From: Simon Davis
Sent: 09 July 2019 12:40
To: Planning.Responses
Subject: FW: Application Ref. Y/48/19/DOC, Seeking the Discharge of Conditions 9 and 10 of Outline Consent Ref. Y/5/17/OUT - Land at the Former Cinders Nursery, Cinders Lane, Yapton, BN18 0JJ
Attachments: 19.14.102 D Site Wide Elements (Condition 9).pdf; 020.0096.013 Construction Tracking (Condition 9).pdf
Importance: High

Further to our exchanges of emails below, please find attached a revised Site Wide Elements Plan ref. 19.14.102D and associated Construction Tracking Plan ref. 020.0096.013 to address the attached comments dated 14 June 2019 and made by WSCC Highways on the above application, specifically with respect to condition 9 of outline consent ref. Y/5/17/OUT. In particular, please note:

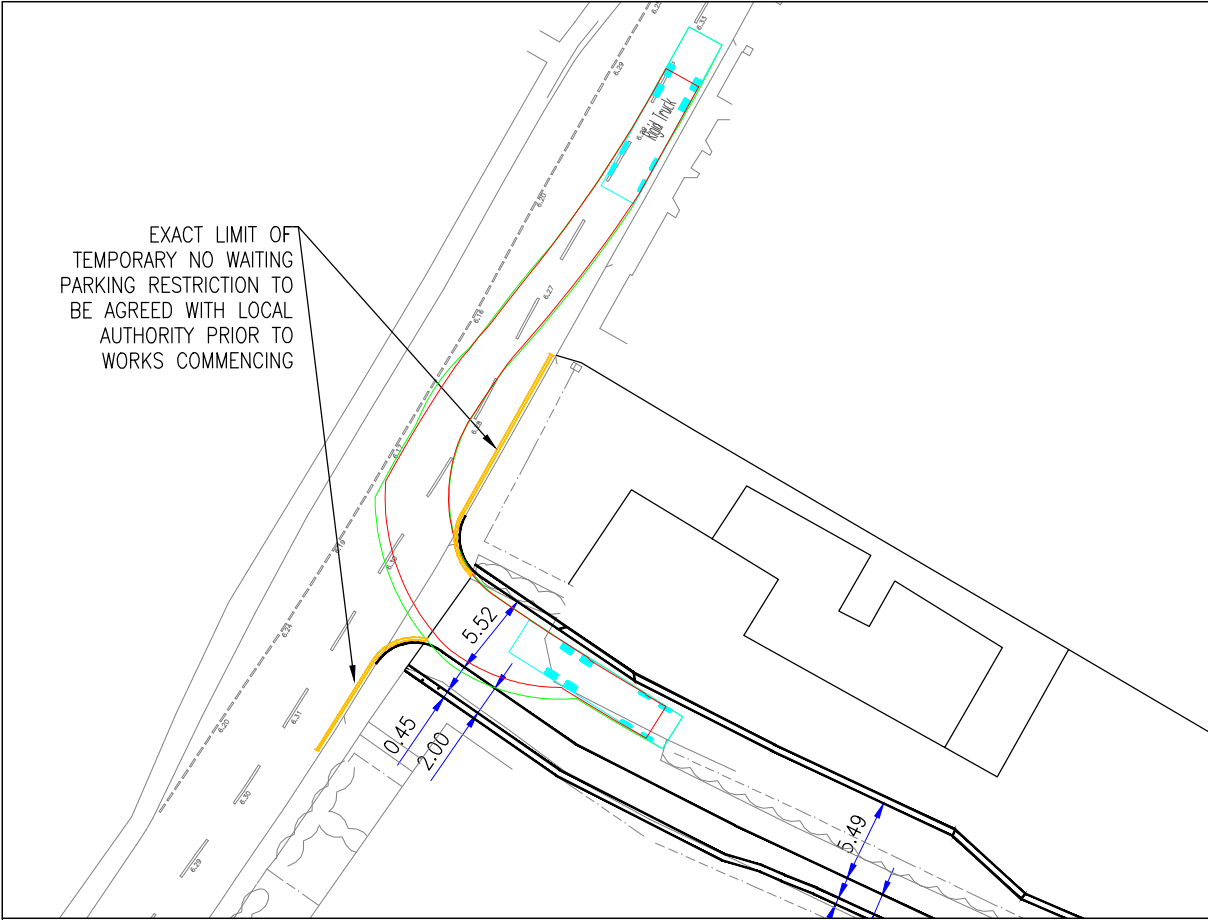
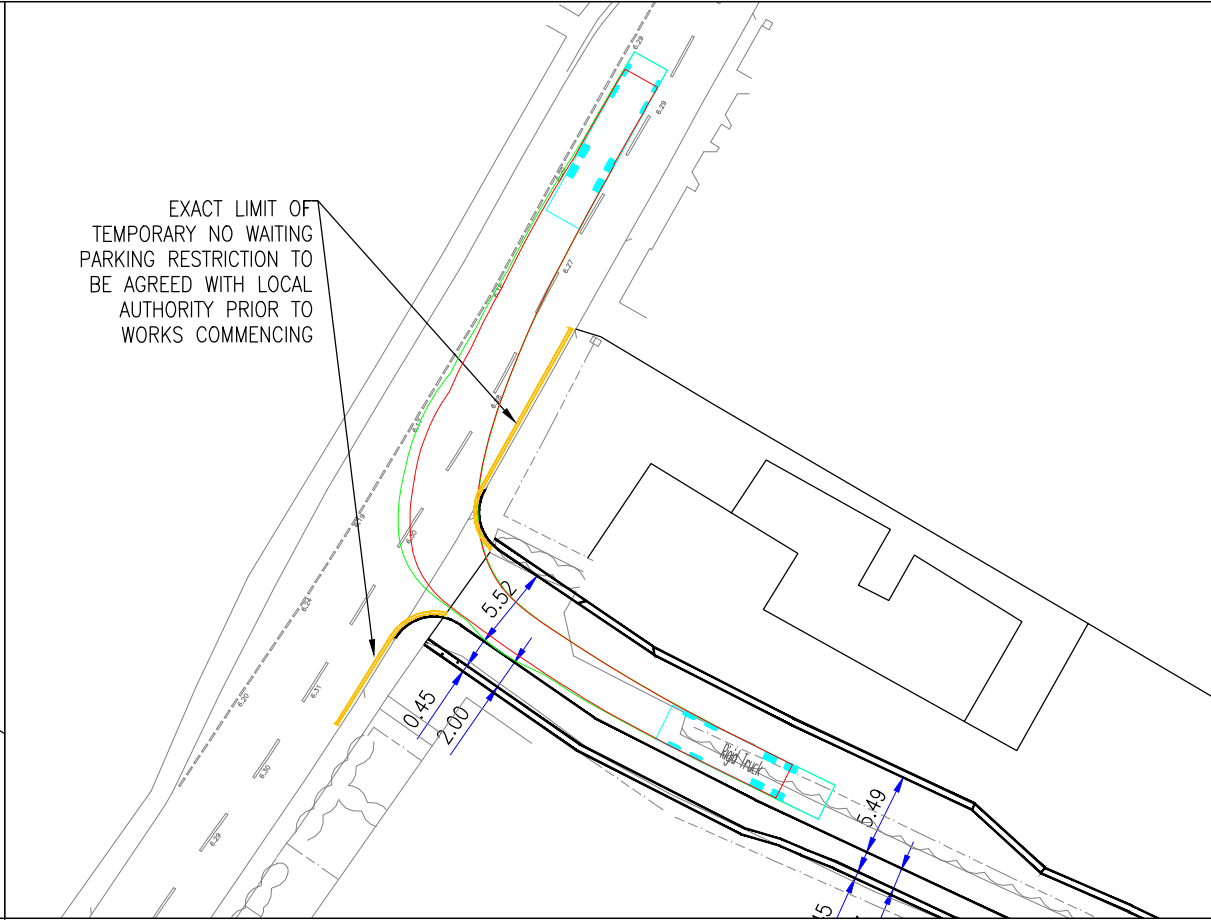
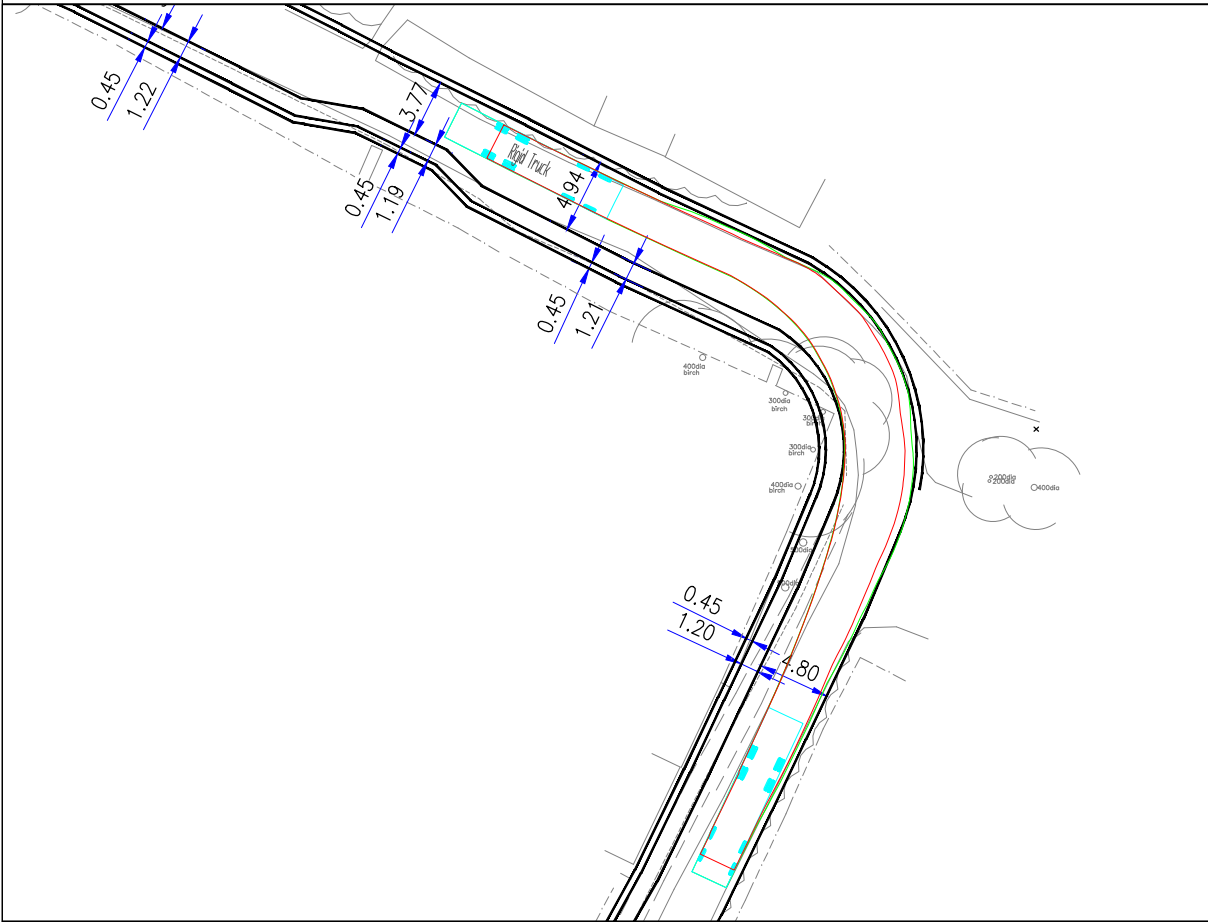
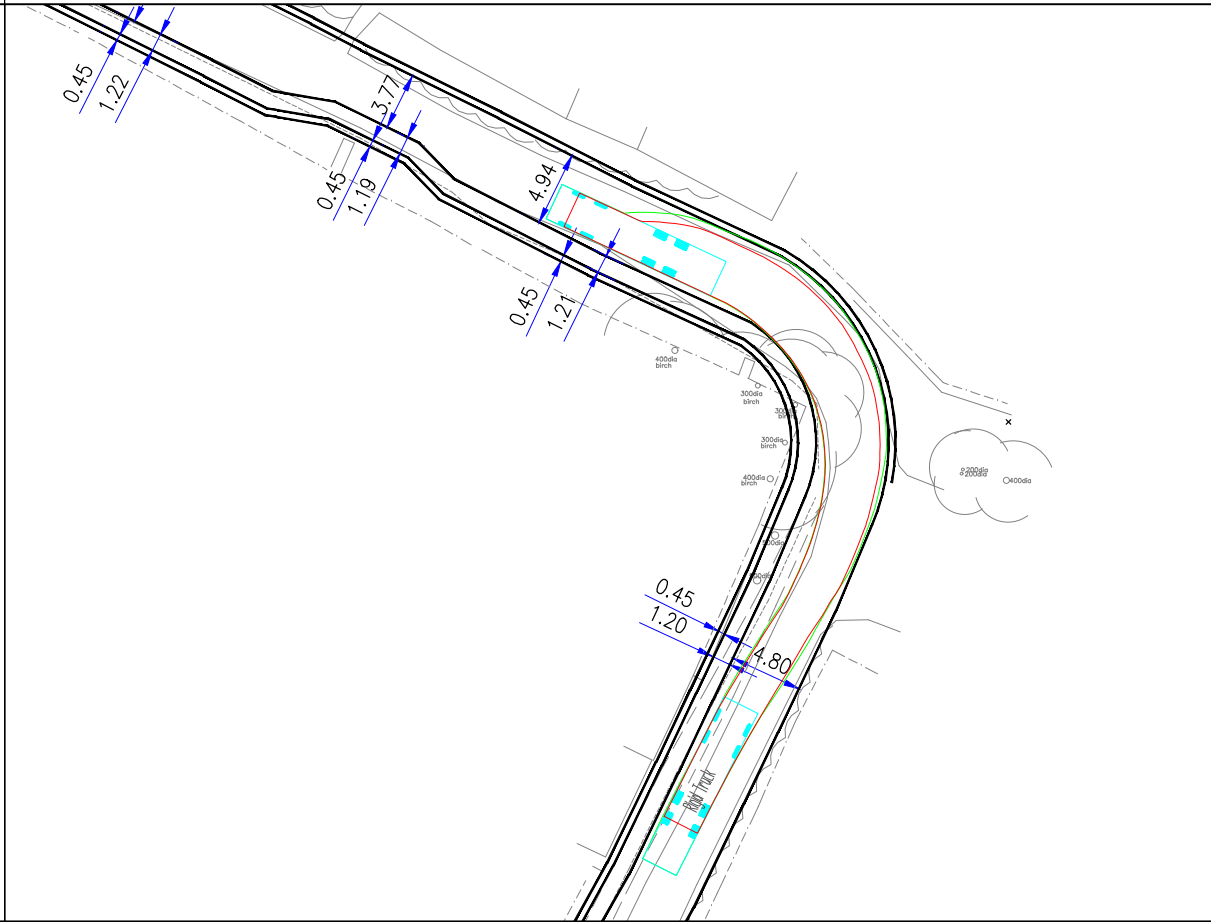
3. There will be no articulated lorries servicing the site's construction phase – the attached Construction Tracking Plan ref. 020.0096.013 has been completed for a rigid lorry of 12m, which can be accommodated without the need for a temporary Traffic Regulation Order (TRO).

Construction Method Statement

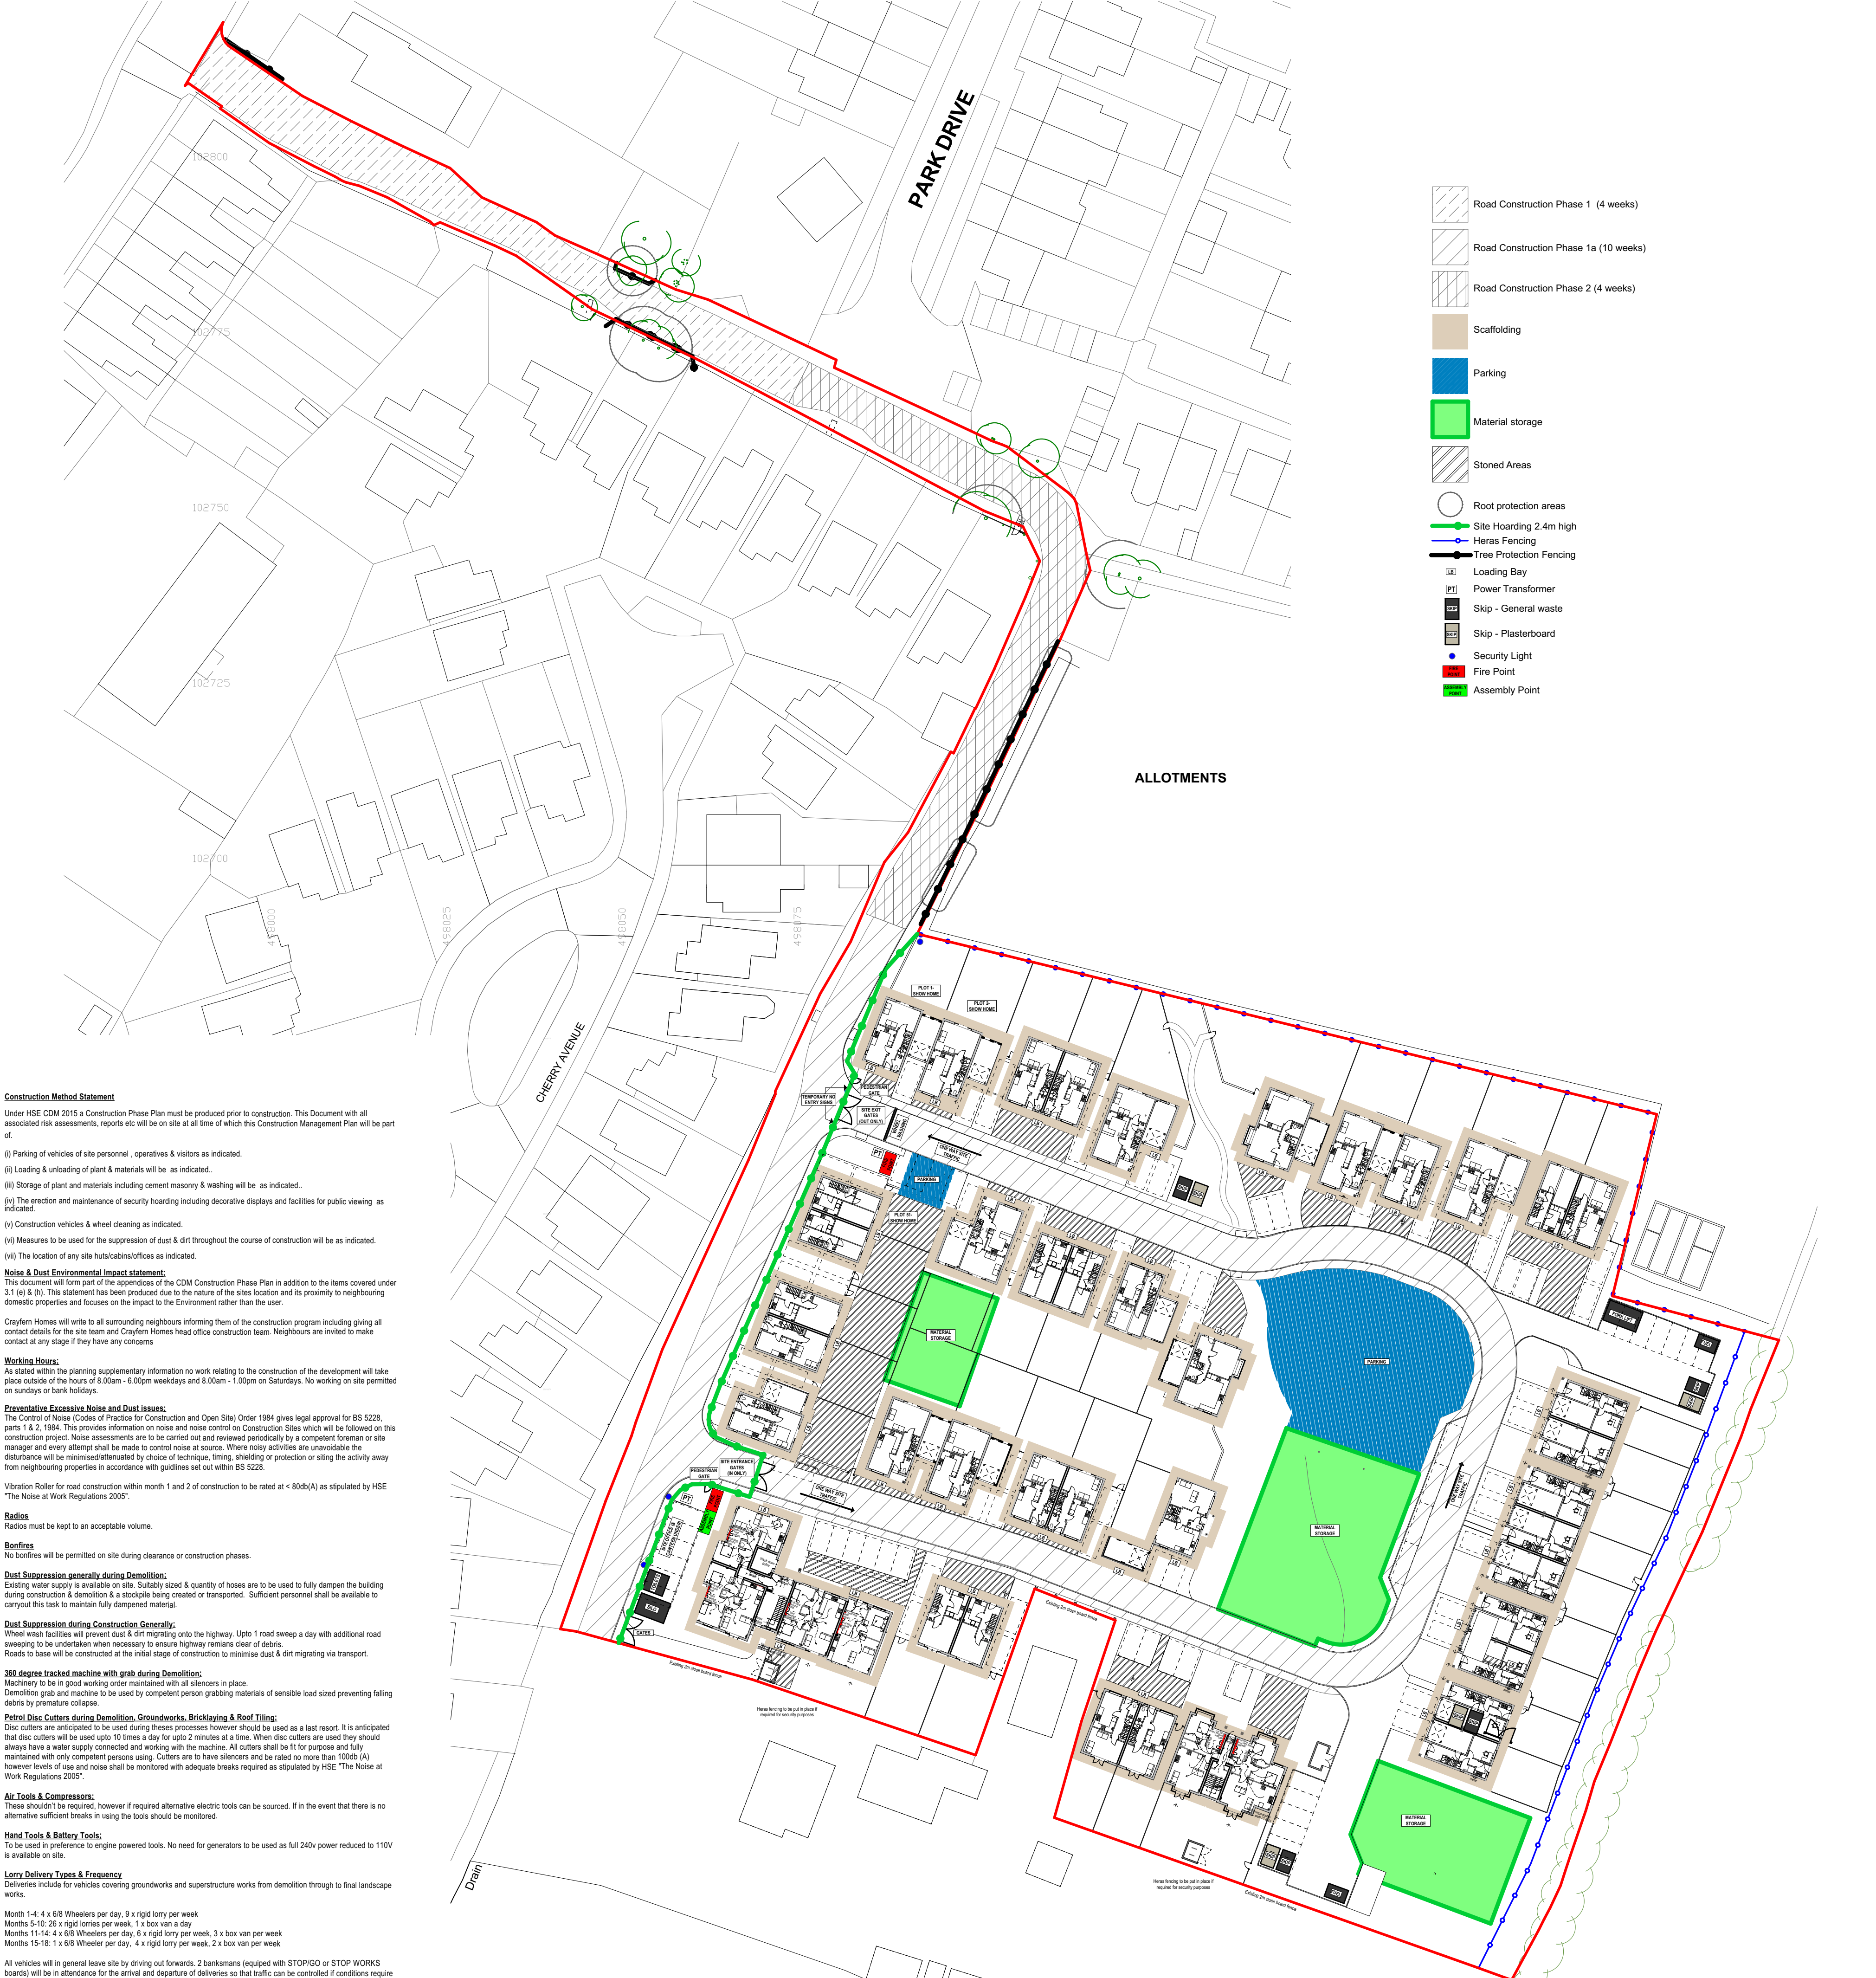
1. Out of hours contact details will be made available to local residents and on the site's hoarding and entrance gates. This is covered by a note on the Site Wide Elements Plan ref. 19.14.102D.

2. As construction of the site's access road progresses, Heras fencing will form a temporary gated access to the construction area. Upon completion of the site's access road, the site entrance gates will be as shown on the Site Wide Elements Plan ref. 19.14.102D, as per the note added to the same.

4. The site's construction phase is anticipated to be 18 months. This is also covered by a note on the Site Wide Elements Plan ref. 19.14.102D.
